RE: Falcon Reserve Ponds (2nd Submittal)

Final Drainage Report:

FALCON RESERVE PONDS				POND 1 OUTLET STRUCTURE PLAN			
210 N WAHATCH AVE, STE 305 COLORADO SPRINGS CO 80903 PHONE: 719.555.5465				PROJECT NO. 43-144A			
DATE: 08/10/2026				SCALE: HORIZONTAL: N/A VERTICAL: N/A			
DESIGNED BY: GT				DRAWN BY: GT			
CHECKED BY: VAS				SHEET 3 OF 21			
PCN 03

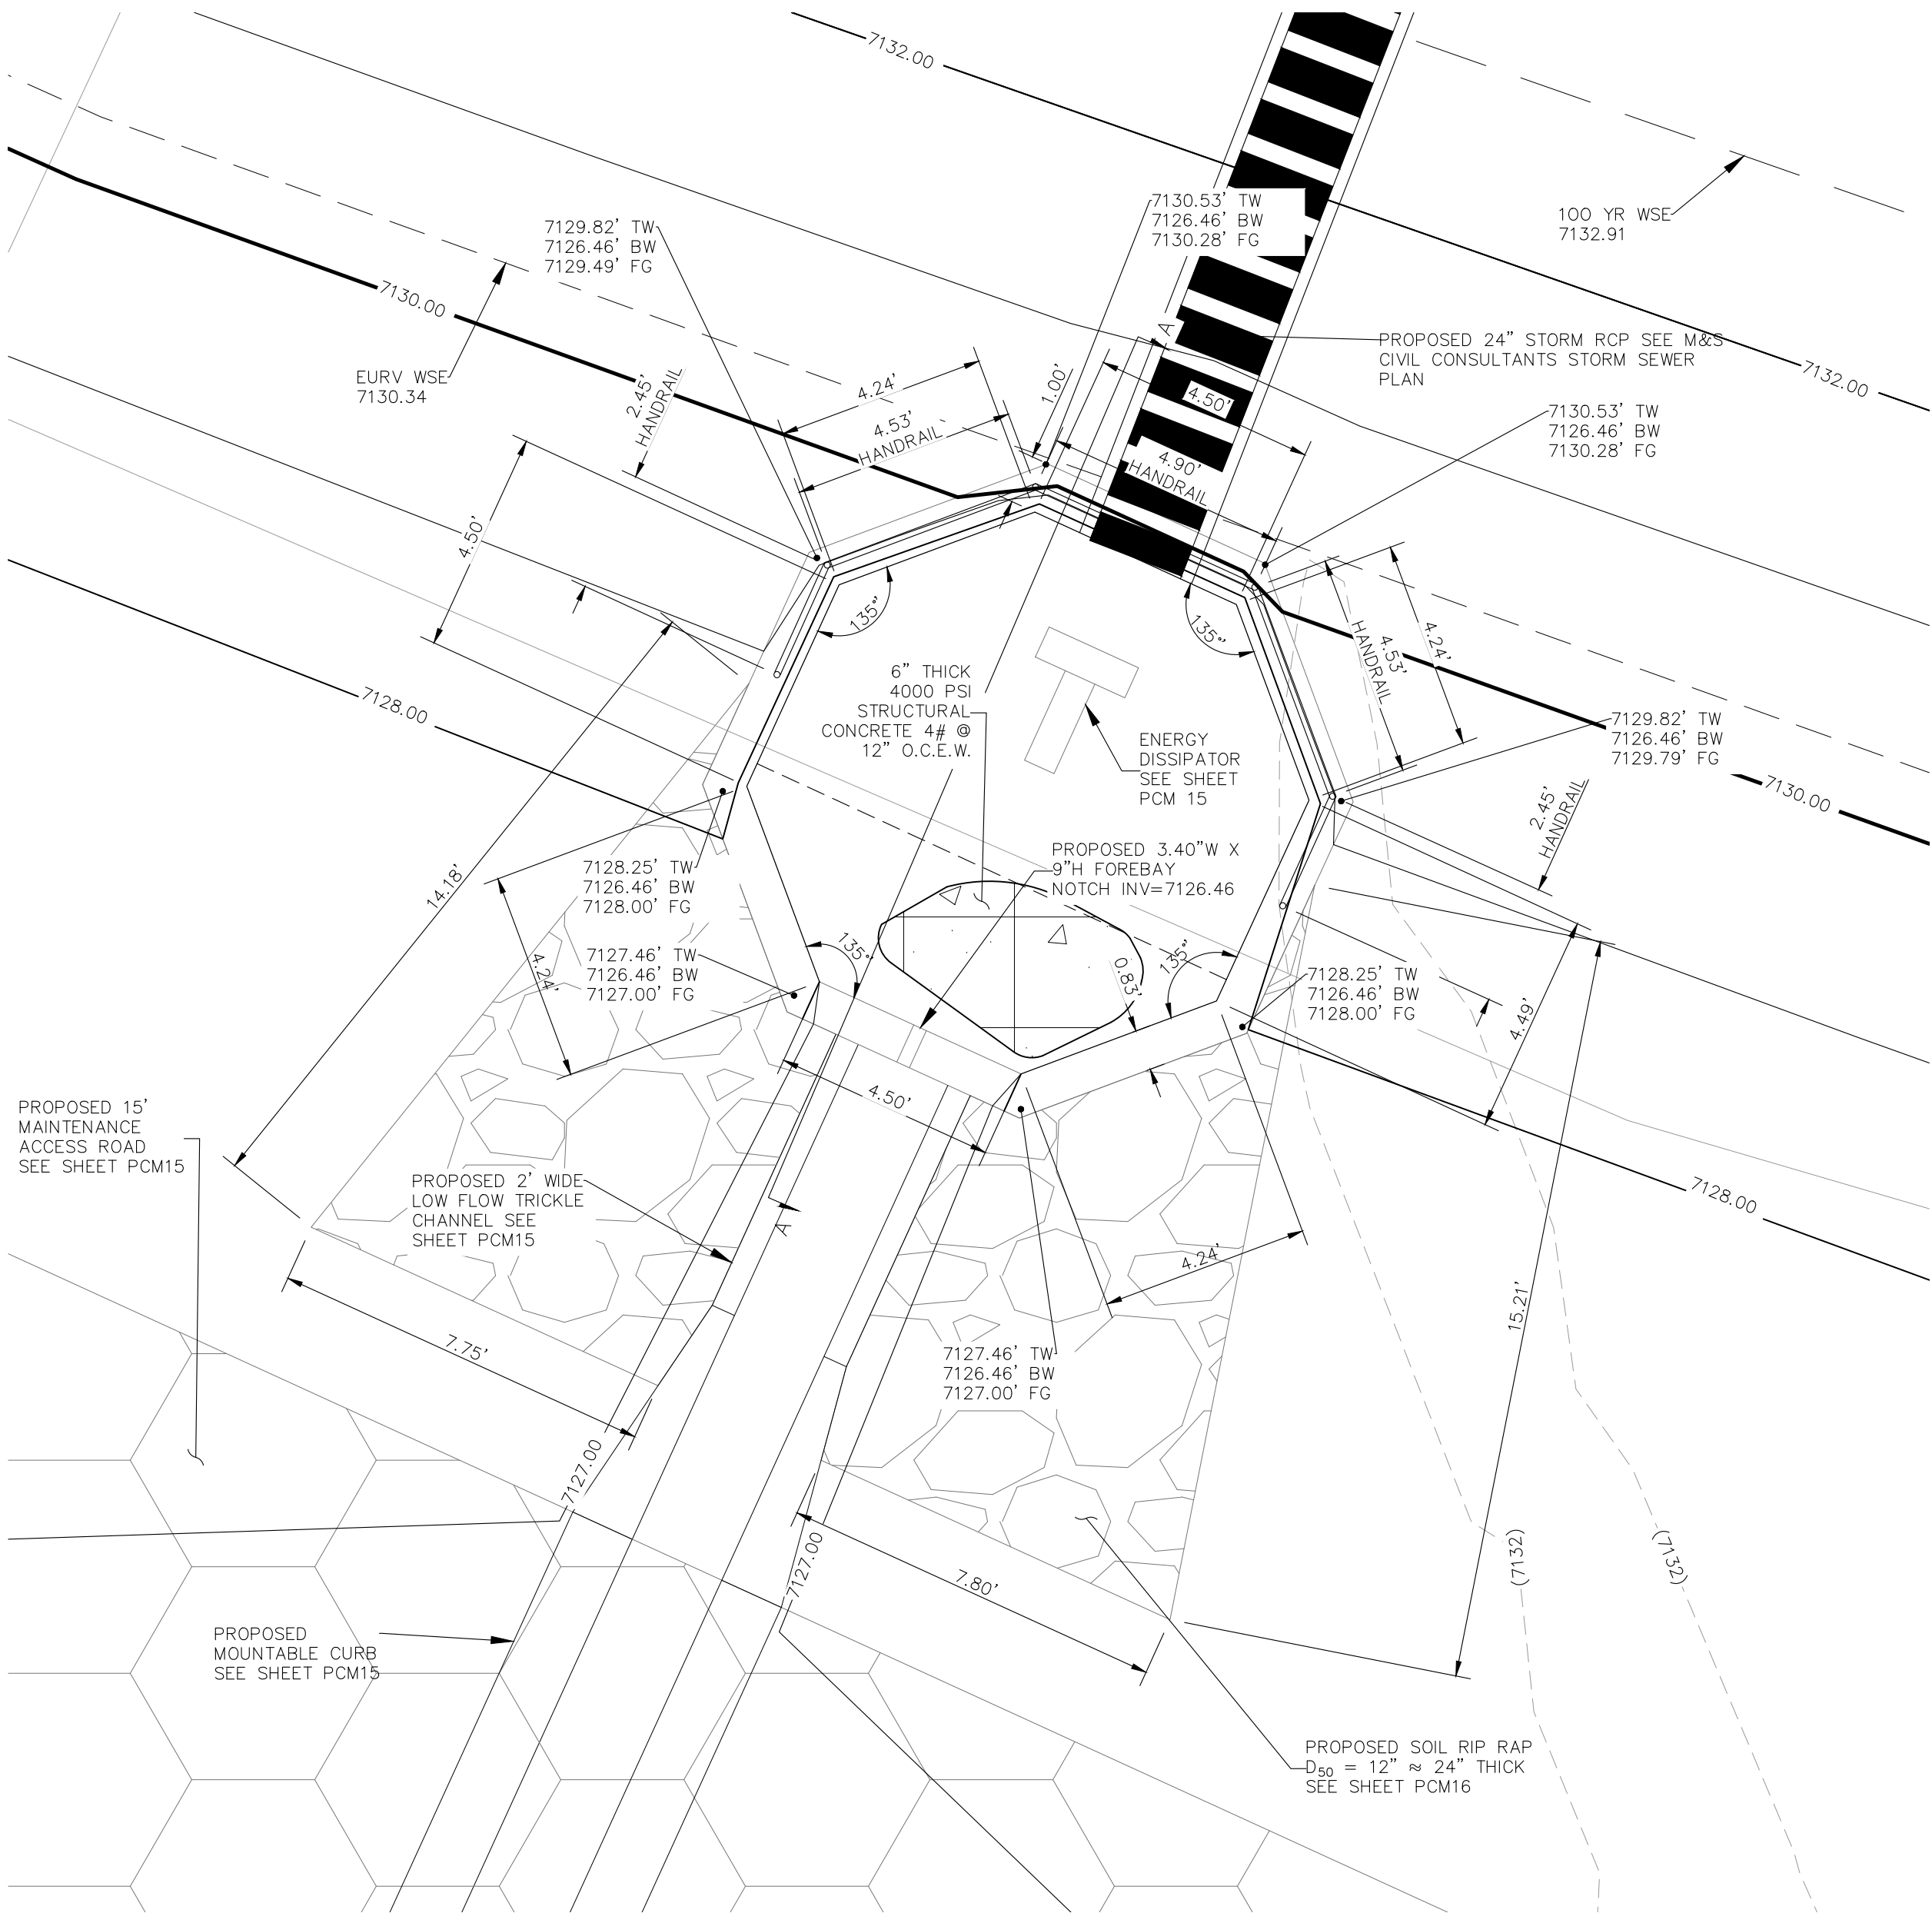
Comment 1: (EPC Stormwater – Zachary) ‘These values should be flipped’ (Pond 1)

These values
should be flipped

M&S Response: [Acknowledged](#). [Updated accordingly](#). Please reference updated MHFD spreadsheet.

POND 2 OUTLET STRUCTURE PLAN

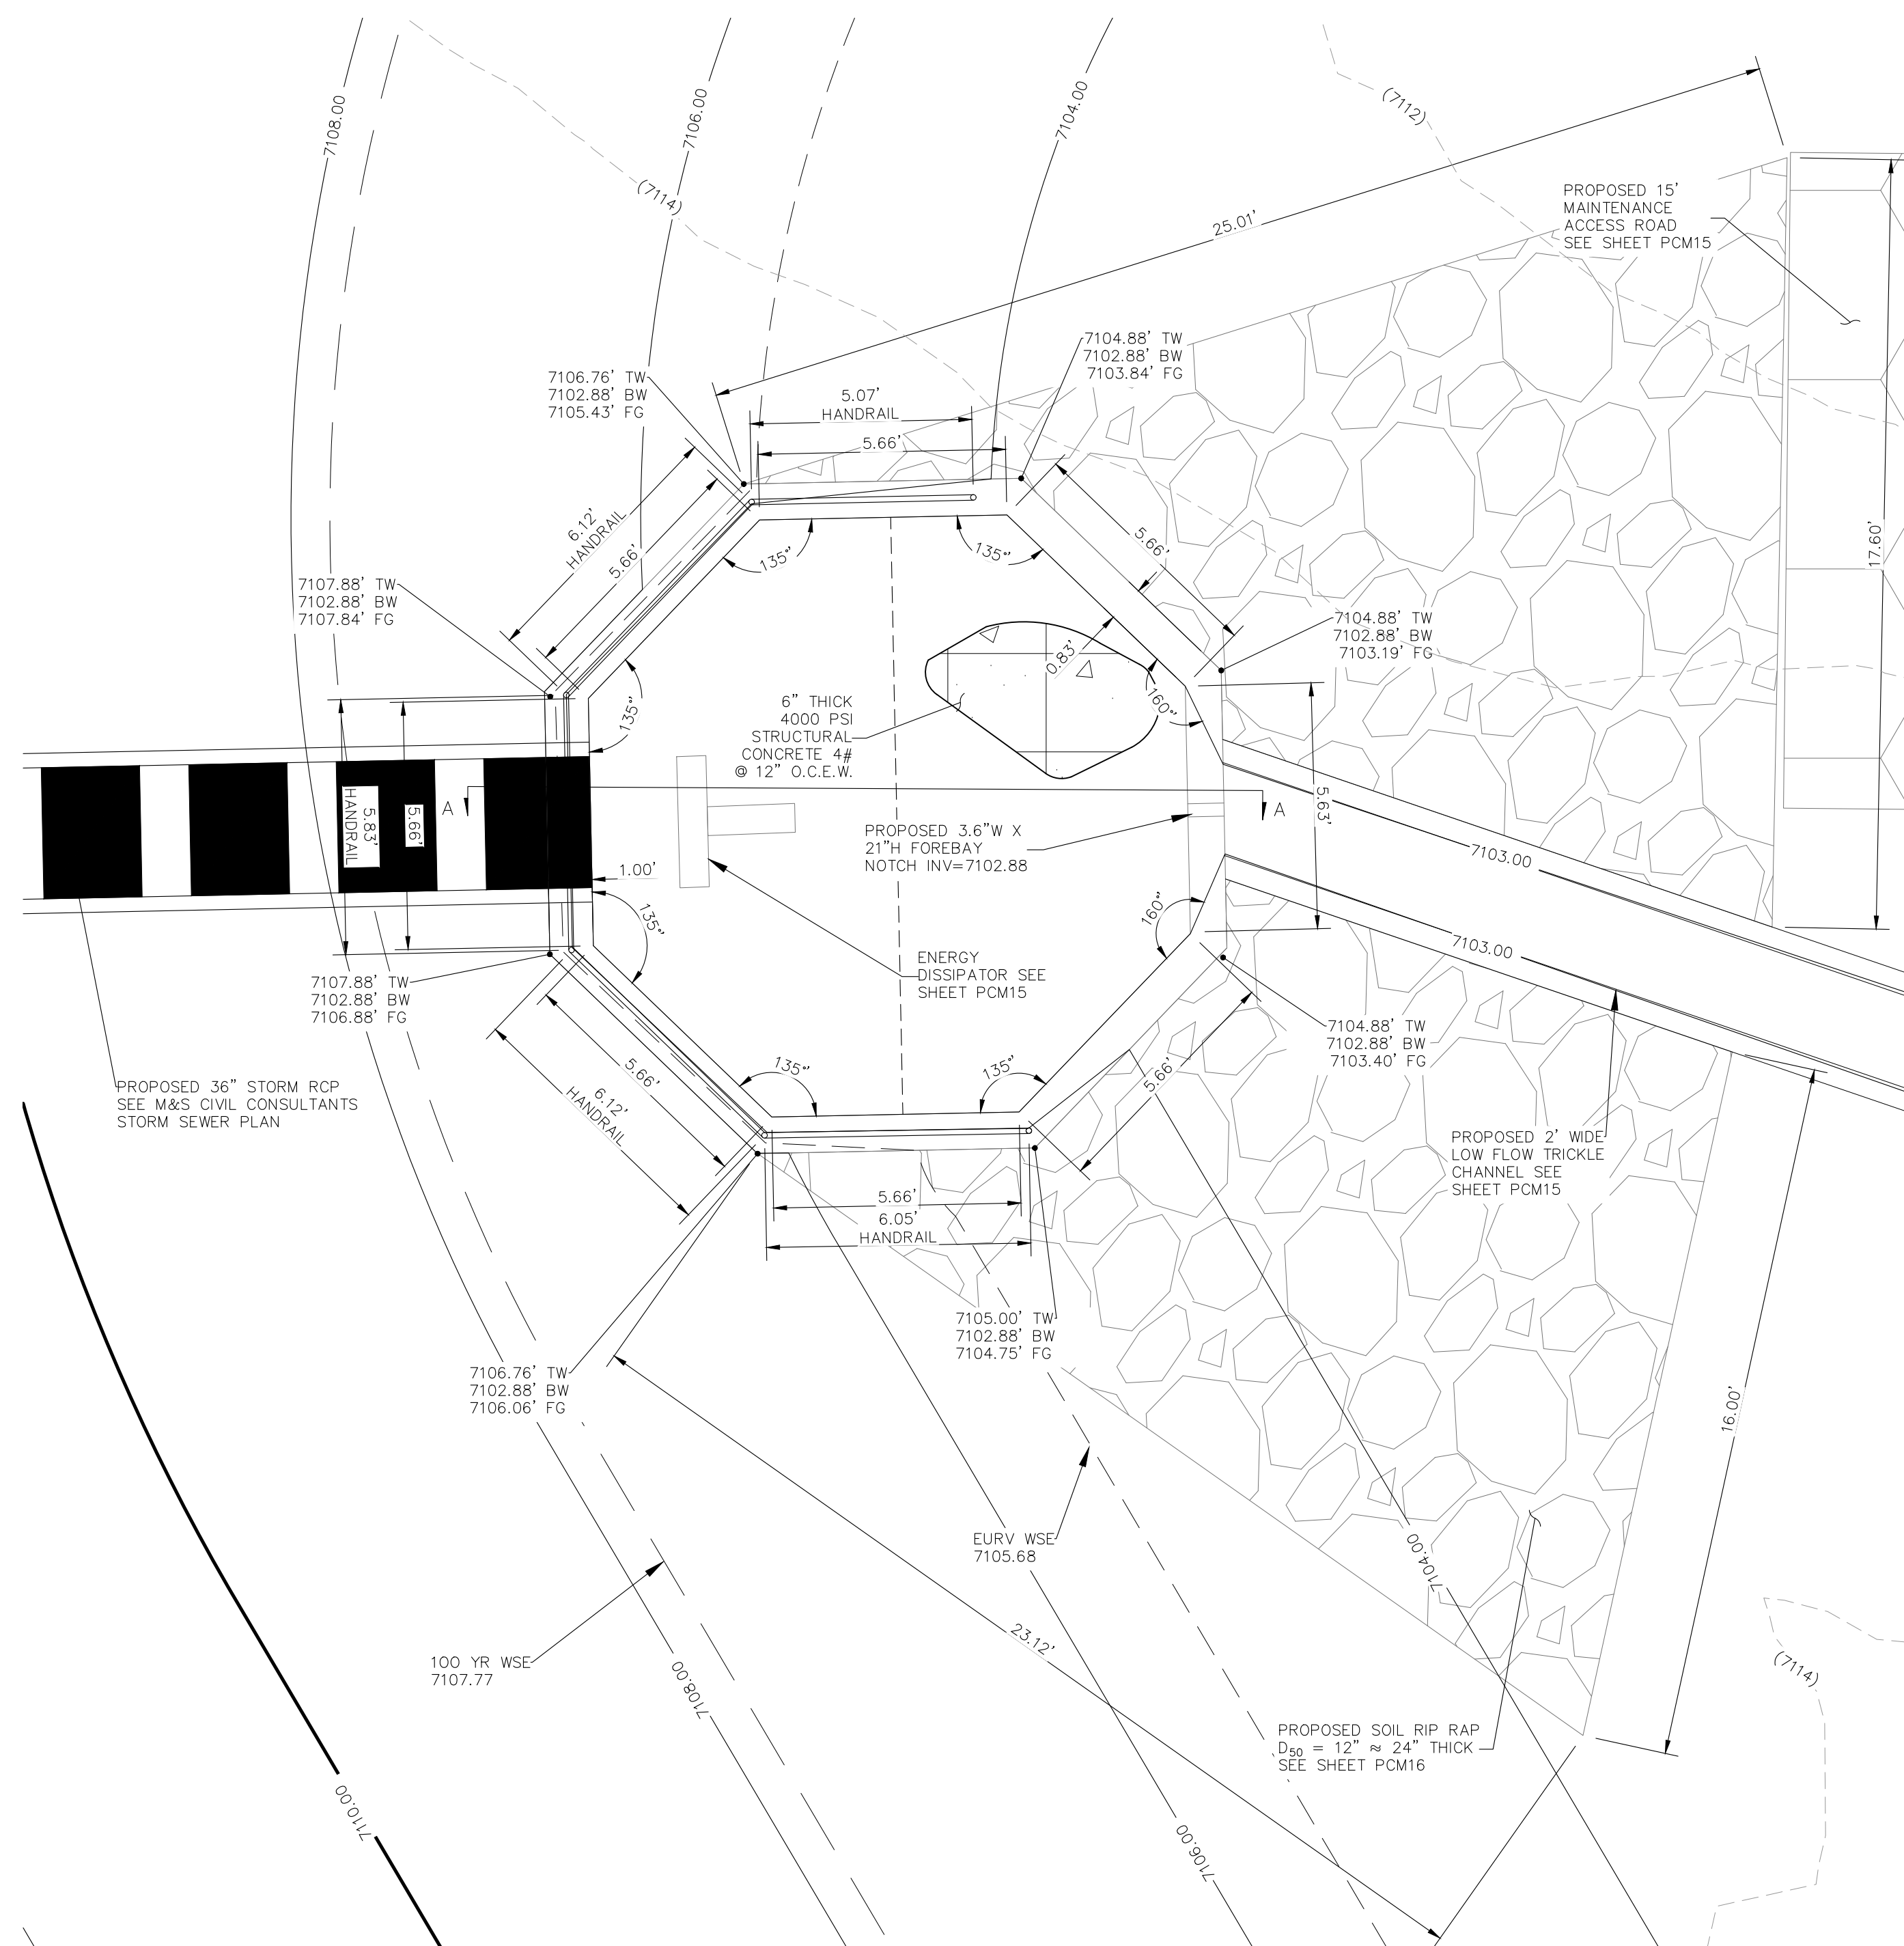
Comment 2: (EPC Stormwater – Zachary) ‘Calcs do not match details in plans’ (Pond 2)

Comment 4: (EPC Stormwater – Zachary) ‘Calcs do not match details in plans’ (Pond 2)

M&S Response: [Acknowledged. Updated Storm & PCM Plans accordingly to match orifice hole sizes and spacing.](#)

M&S Response: [Acknowledged. Updated Storm & PCM Plans accordingly to match 21”.](#)
